**CITY OF ALBUQUERQUE
PLANNING DEPARTMENT**

October 1, 2014

DRB Comments

RE: Tracts 1 & 2, University Heights

14-0378.DWG (AUGUST, 2014)

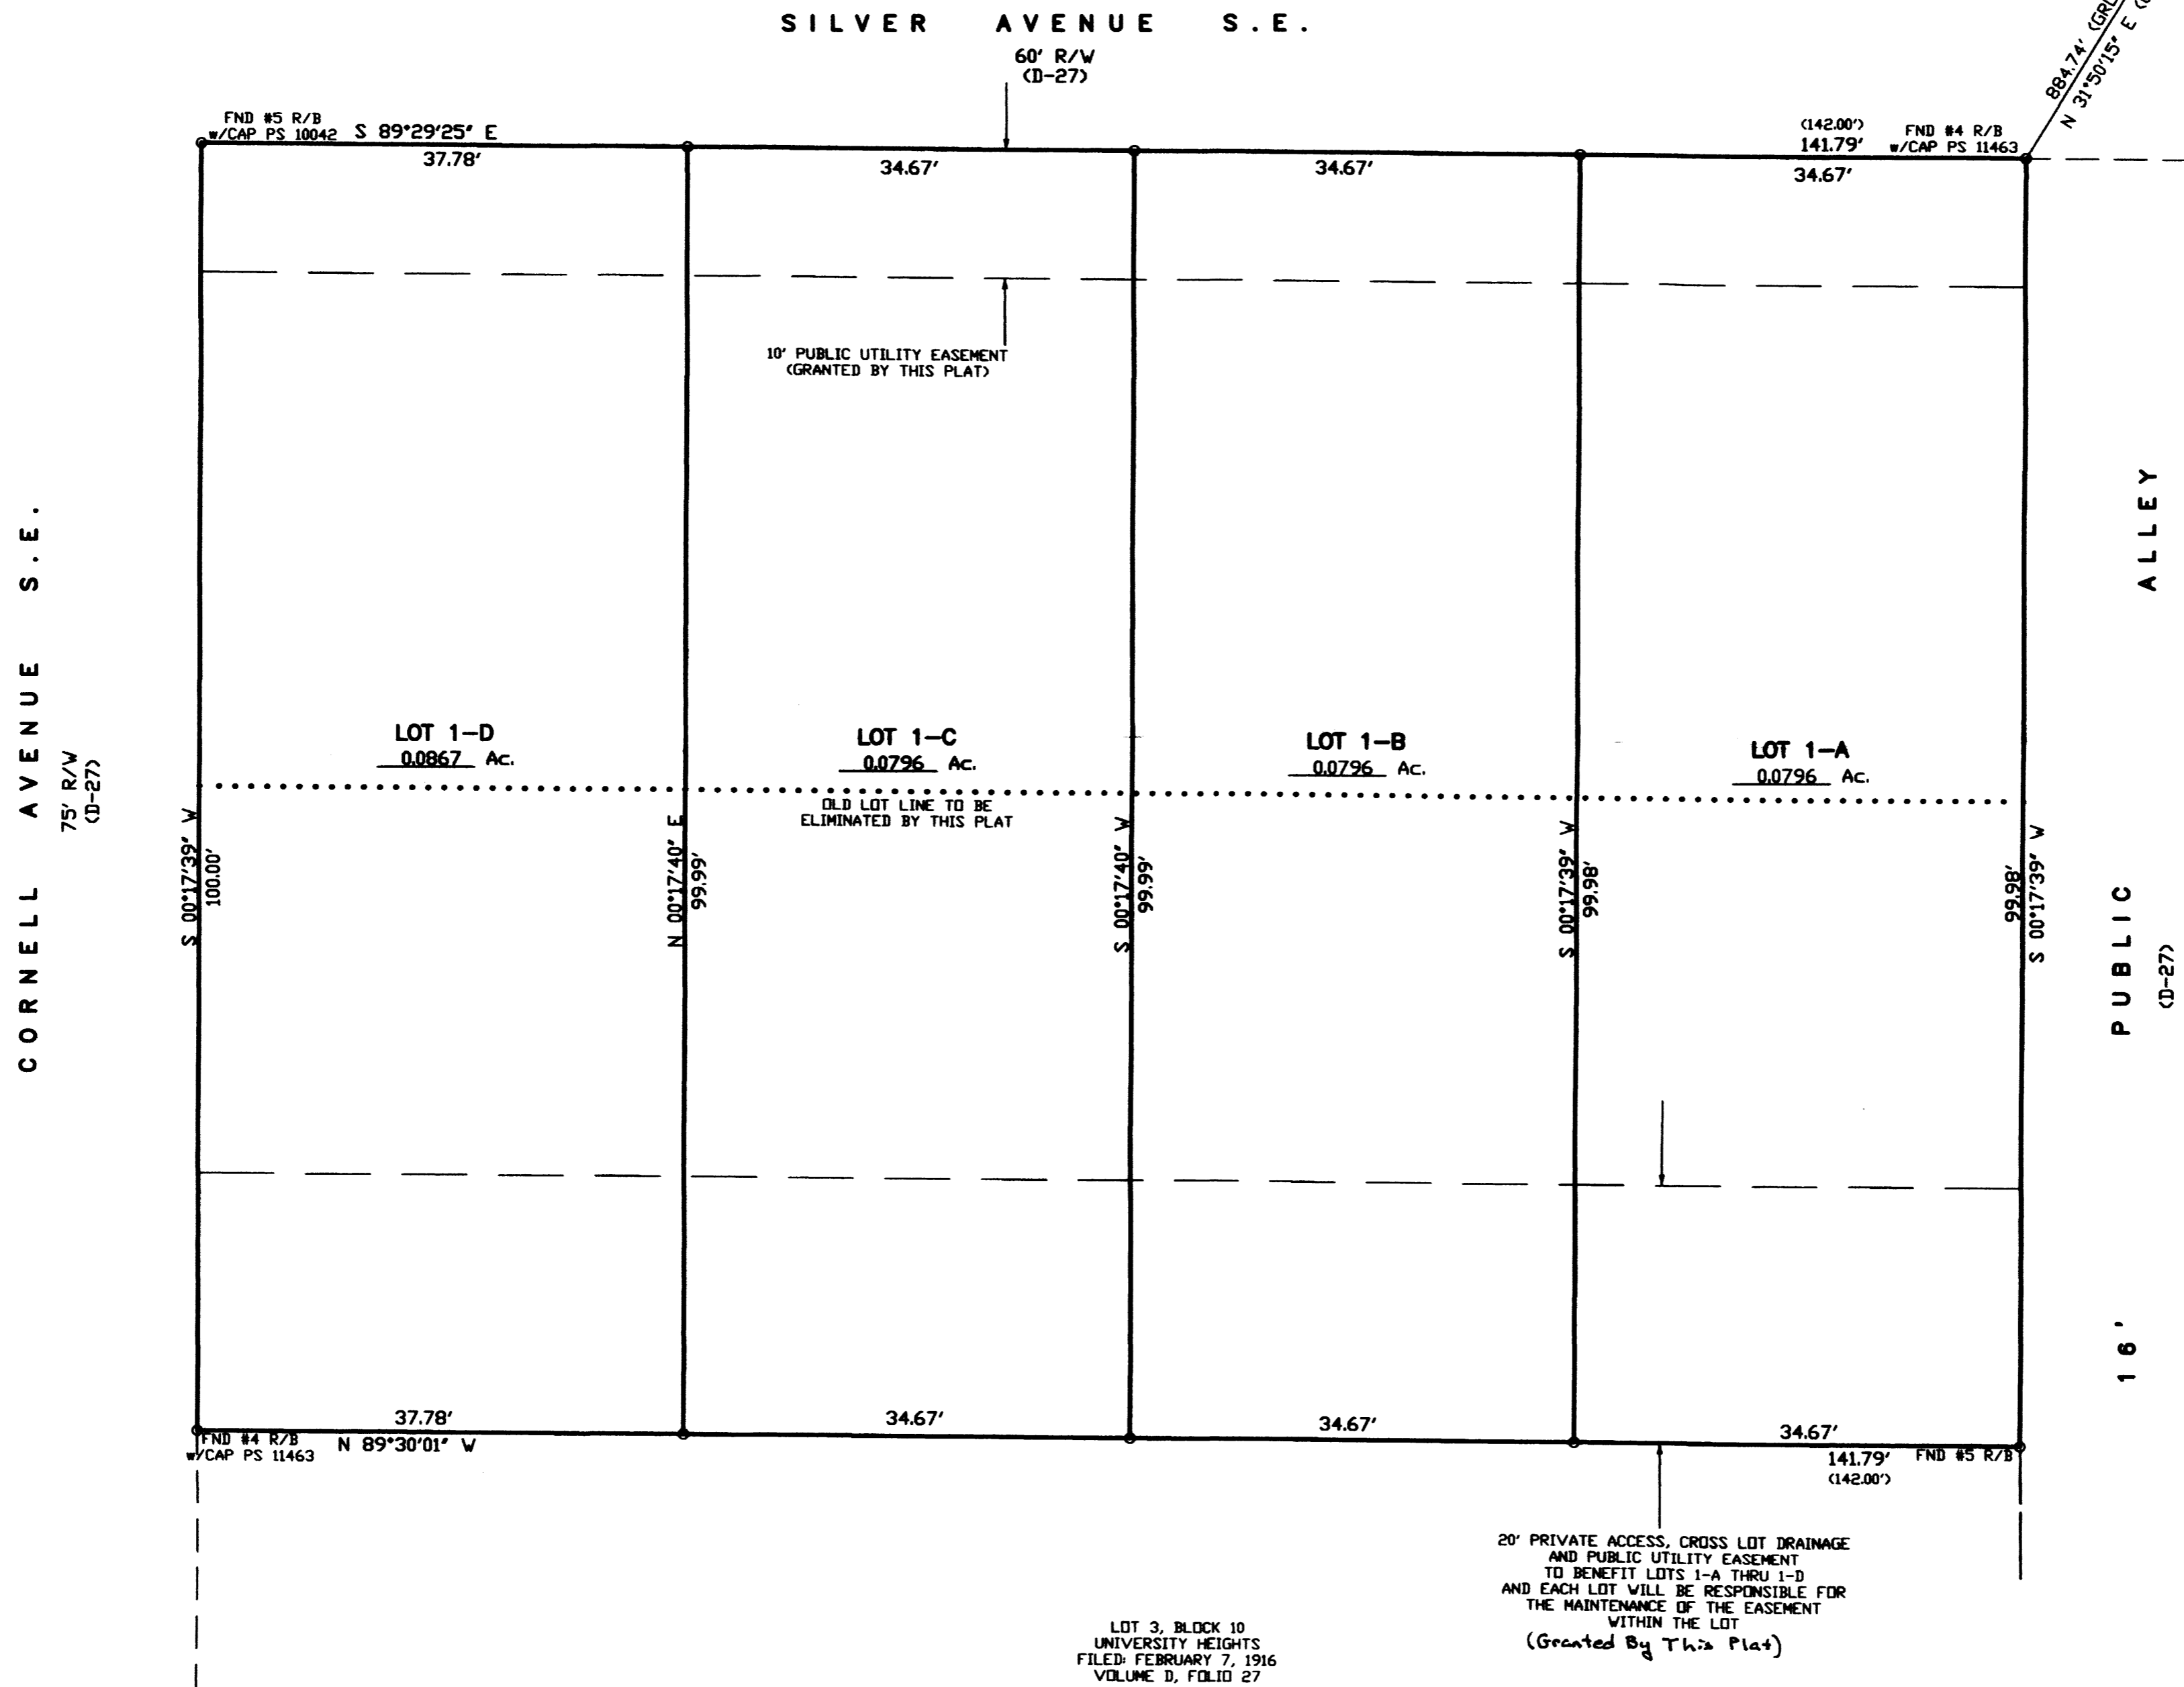
The rear easement needs to be inclusive of "Private Water Service."
An Infrastructure List is needed for the private easement.

PROJECT TITLE SILVER AVENUE TOWN HOMES 202 CORNELL SE, ALBUQUERQUE, NEW MEXICO	
SHEET TITLE MASTER GRADING & UTILITY PLAN	
PROJECT NO. 1410	SHEET NO. C101
DATE 09/18/2014

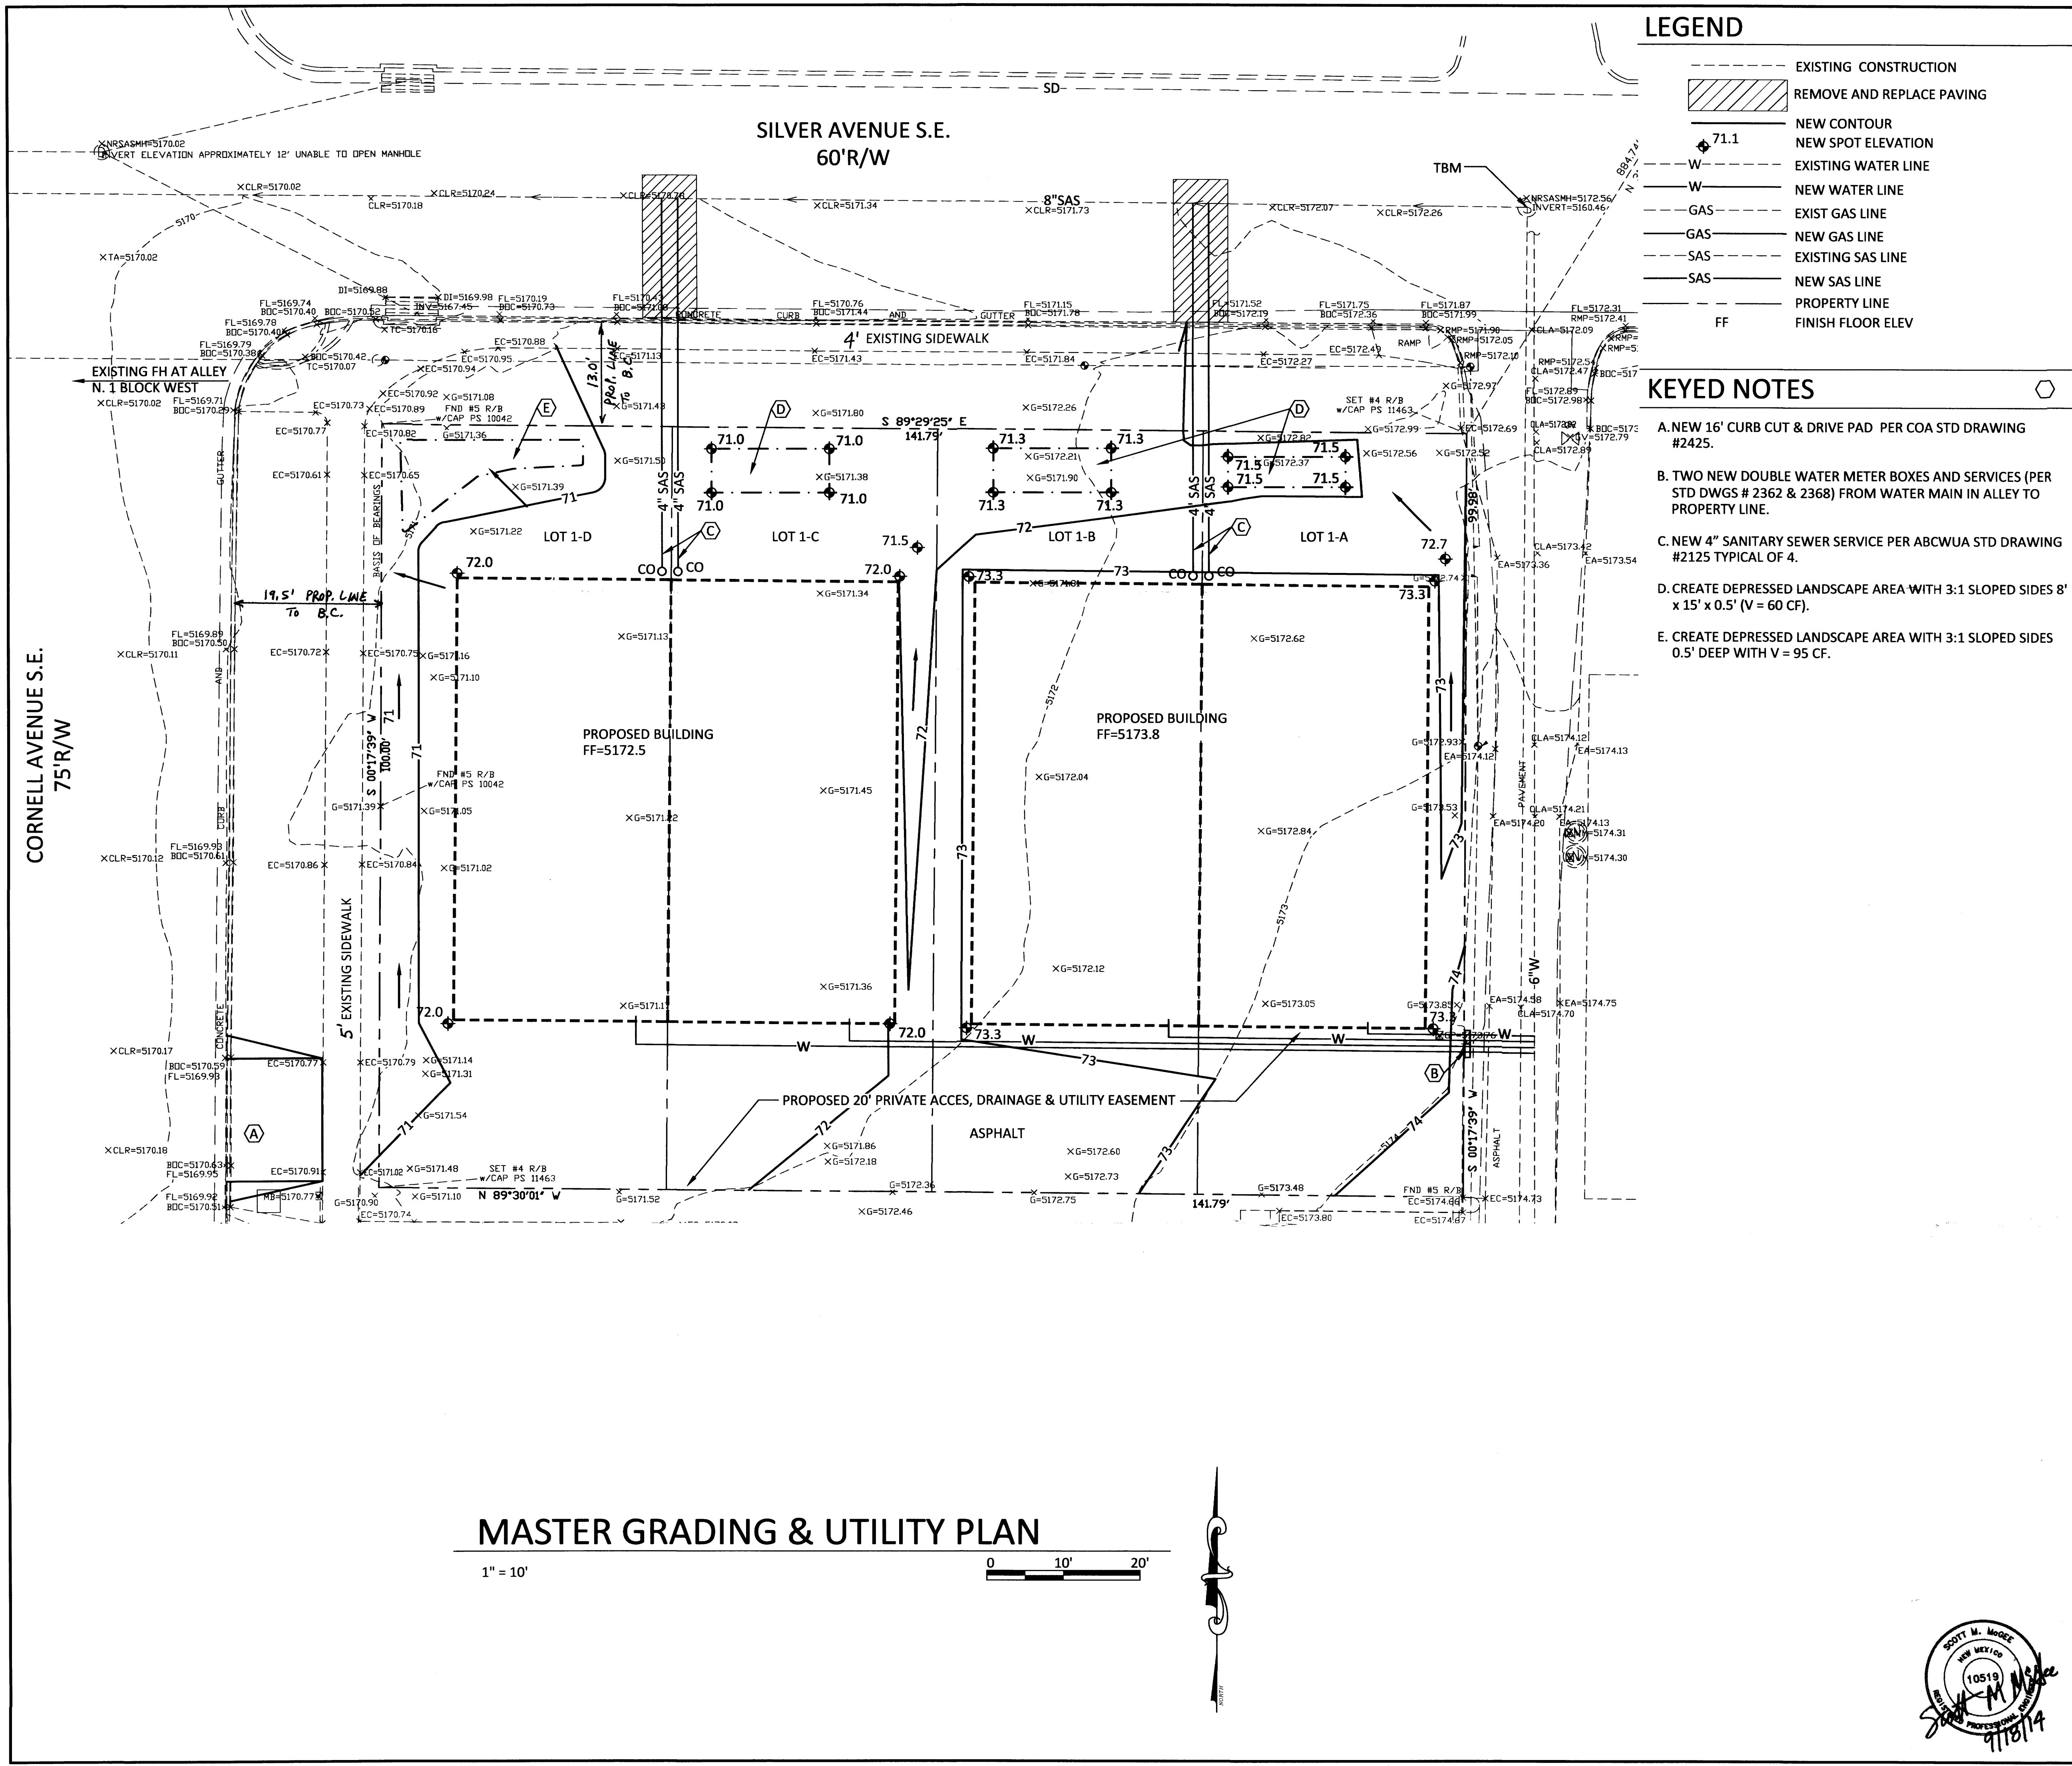
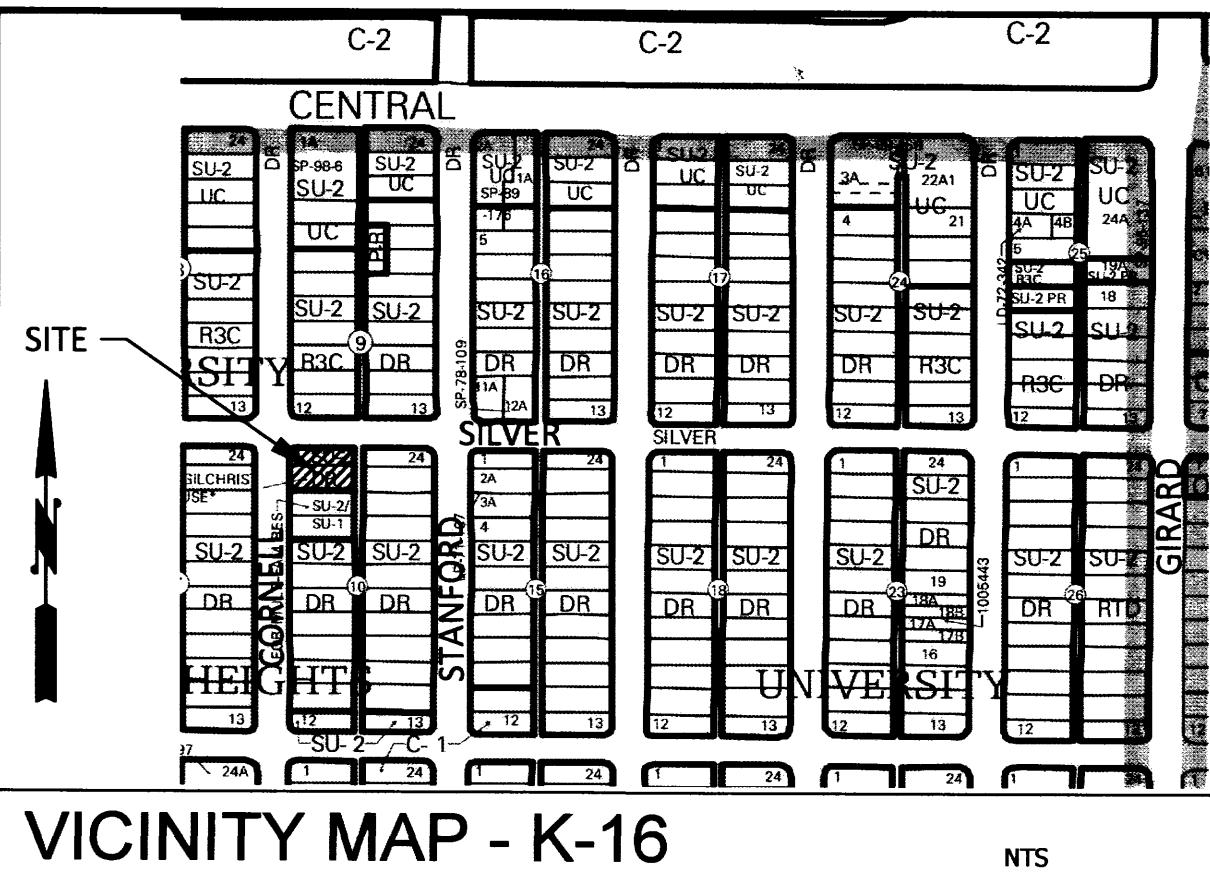
The front setbacks on the Grading and Drainage Plan do not conform to the approved Variance(s). This is key to providing adequate maneuvering space for the rear garages.
